Your ref: 22.0568  
Our ref: D3.22.0568  
Date: 27<sup>th</sup> February 2023

**App no: 22.0568**

**Address: Land to rear of Malt Kiln House Malt Kiln Brow Chipping**

**Proposal: Four new, two-storey residential dwellings**

| June 2022 | 1:500 @ A3 | SDH | MKB/P03 | D |

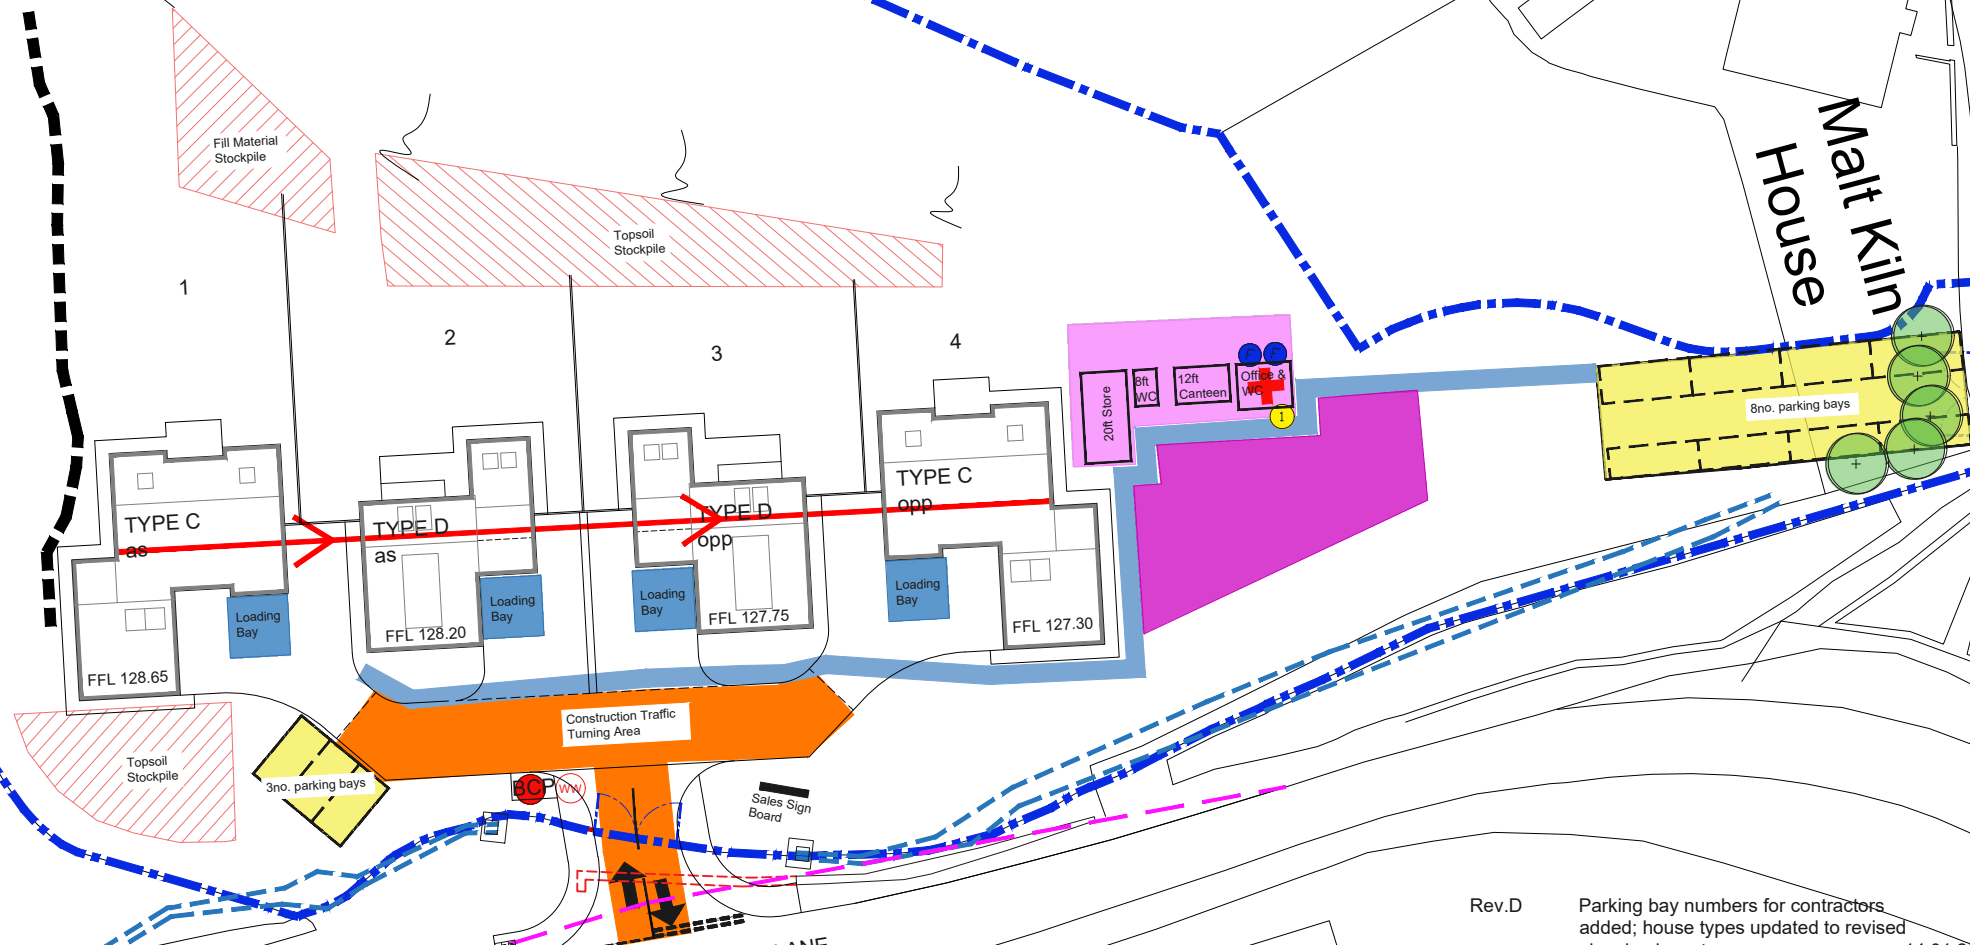
The amended plan Rev D shows 8 operative car parking spaces with access from Malt Kiln Brow.

The amended documents are considered acceptable, we would request a condition to ensure these measures are implemented throughout the construction phase.

1. The Construction Traffic Management drawing MKB/P03 Rev D shall be adhered to throughout the construction phase.
2. Upon completion of the construction phase, the vehicle access and hardstanding from Malt Kiln Brow shall be removed and reinstated to its former condition.
